FINAL DRAINAGE REPORT

MERIDIAN ROAD & BENT GRASS MEADOWS DRIVE

DATE:
March 2020
Revised: July 2020
Revised: September 2020

Engineering Review

MERIDIAN ROAD DRAINAGE PLAN

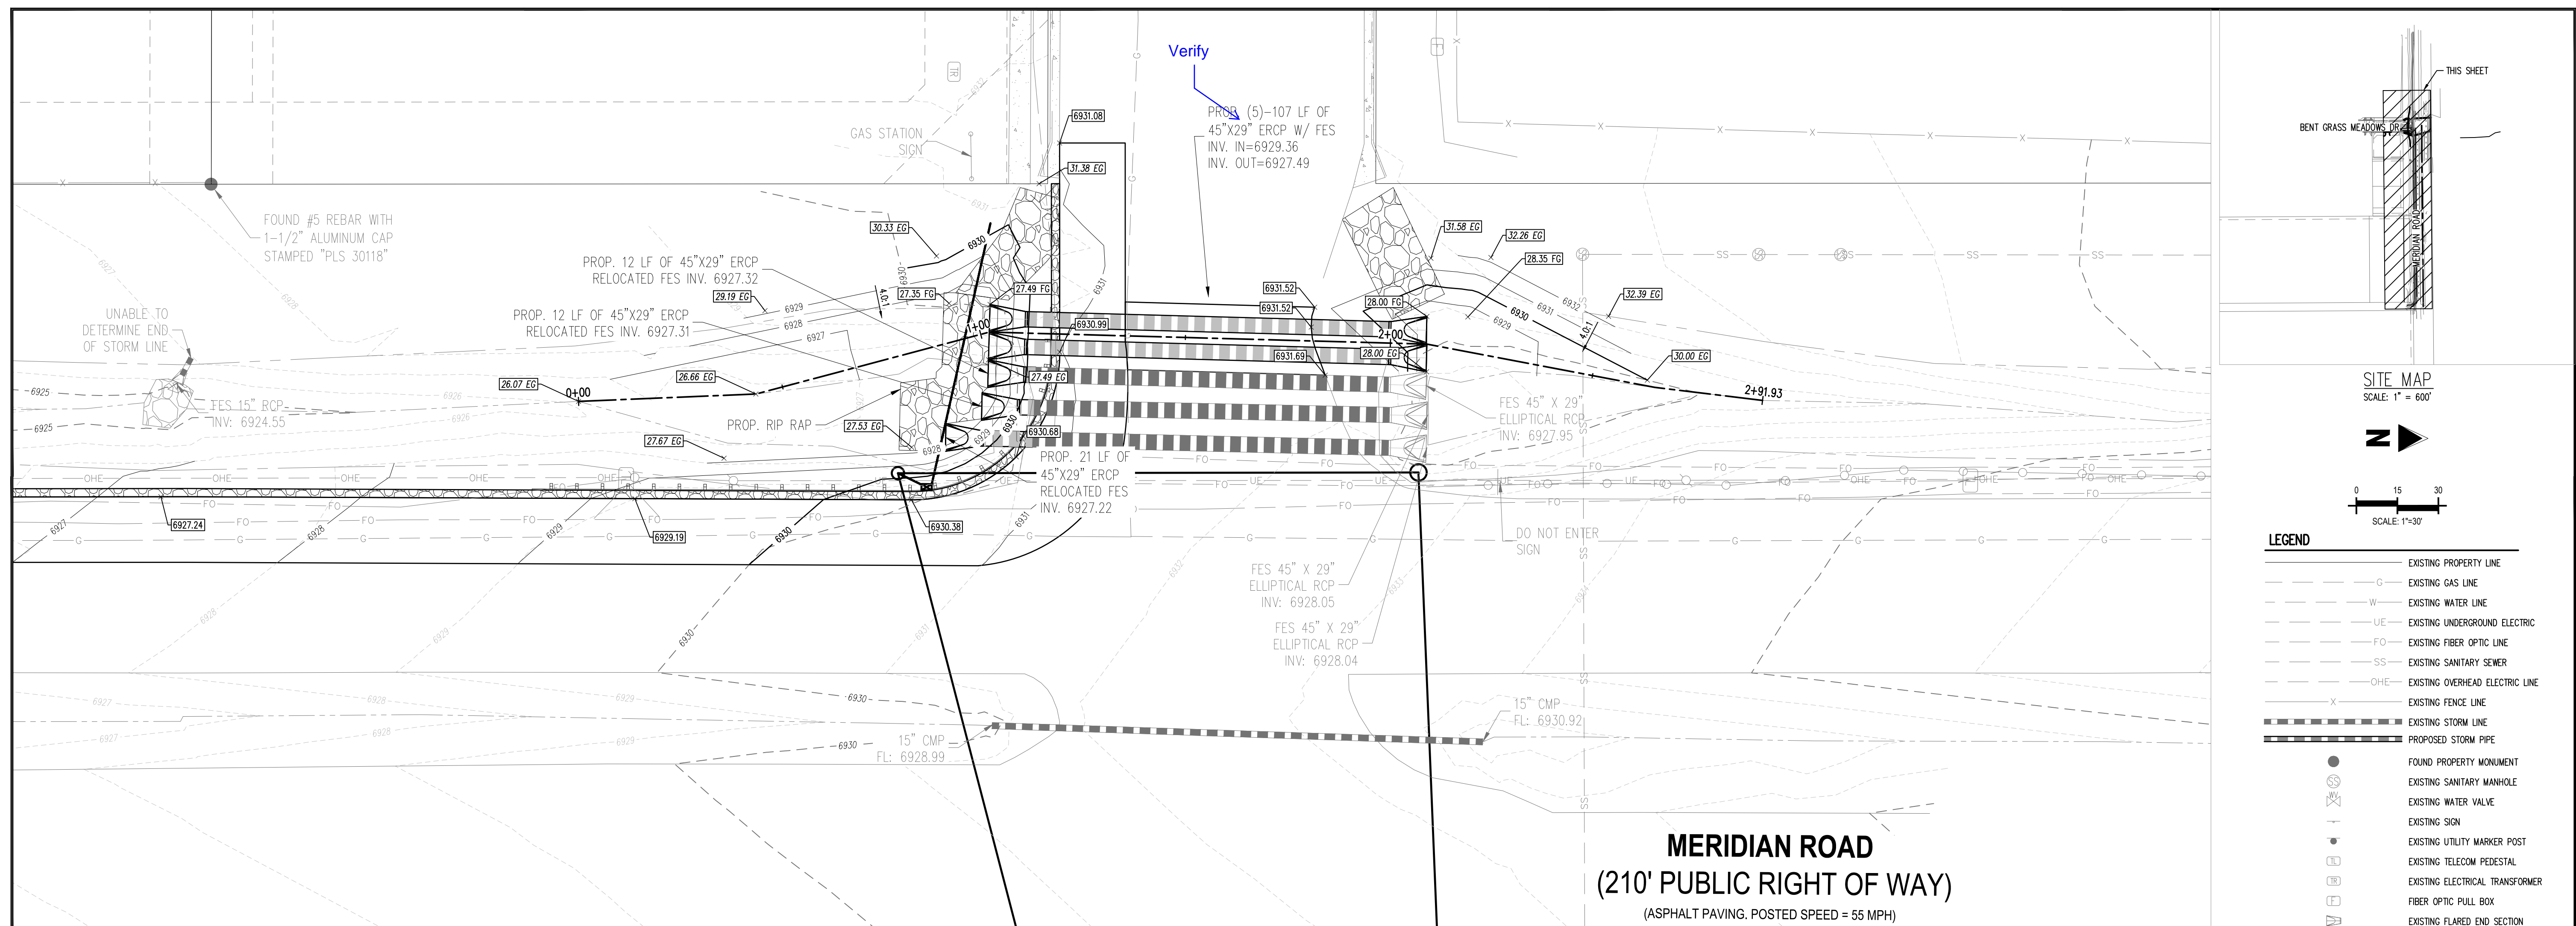
Are these flows actually conveyed to the north flowline? Address street capacity calculations.

Not included - address assumptions in the report narrative.

State the capacity of the cross-section

Address the Owl Place culvert and downstream conditions and necessary easements for increased flow.
